**Subject: Bridle Bit Ranch Filing No.1A (SF-2113)**

The Park Operations Division of the Community Services Department has reviewed the Bridle Bit Ranch Filing 1A Minor Subdivision Final Plat and has the following preliminary comments of behalf of El Paso County Parks. This application and the following comments and recommendations will be presented to the Park Advisory Board on April 14, 2021.

BRIDLE BIT RANCH FILING NO. 1A

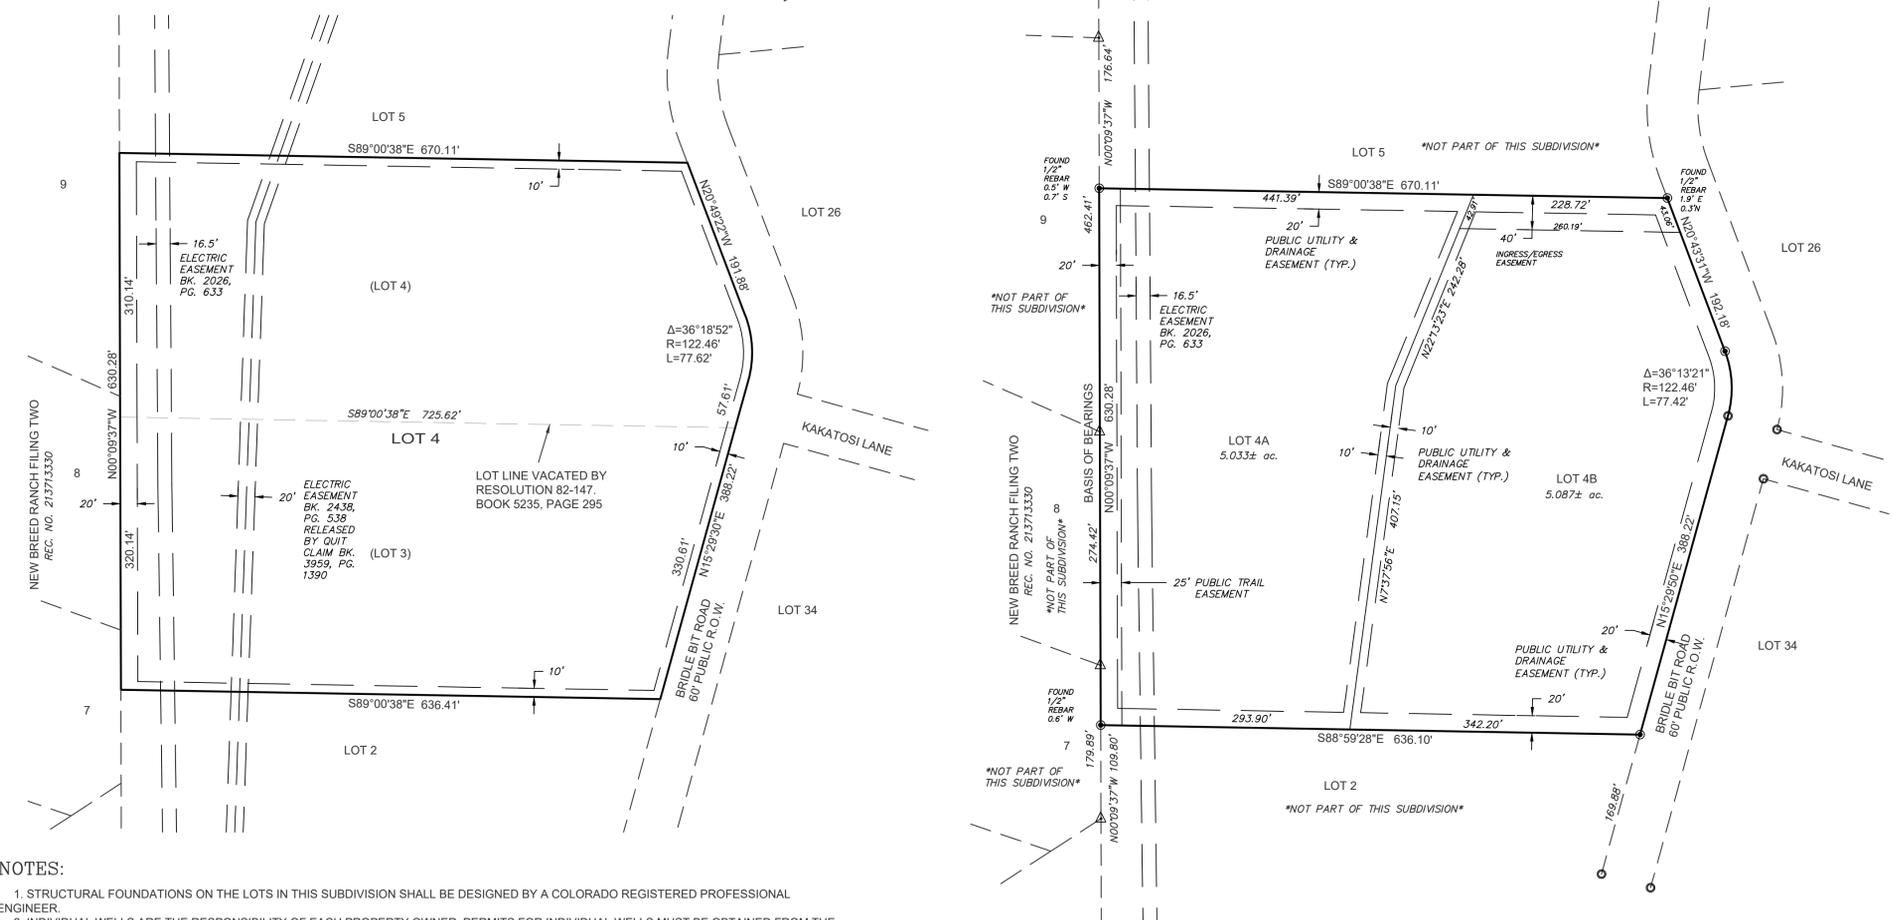
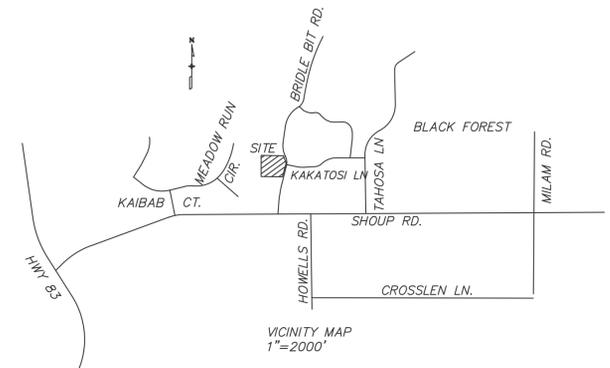
County Parks requests trail easements where development projects impact proposed County trails. As it pertains to this application, the County previously requested that the landowner provide a 25-foot public trail easement along the western boundary of Bridle Bit Ranch Filing No.1A Final Plat (include date). Since this easement is still not shown the final plat drawings, Staff again asks the easement be shown on the Final Plat Drawing.

*The Park Advisory Board recommends to the Planning Commission and Board of County Commissioners when considering and / or approving the Bridle Bit Ranch Filing 1A: (1) Provide to El Paso County a 25-foot trail easement along the western boundary of Bridle Bit Ranch Filing 1A Final Plat that allows for the construction, maintenance, and public access of the LaForet Regional Trail, and dedicate the aforementioned easement to El Paso County prior to the recording of the Final Plat (2) Require fees in lieu of land dedication for regional park purposes in the amount of \$920 which will be required at the time of recording of future final plat(s).*
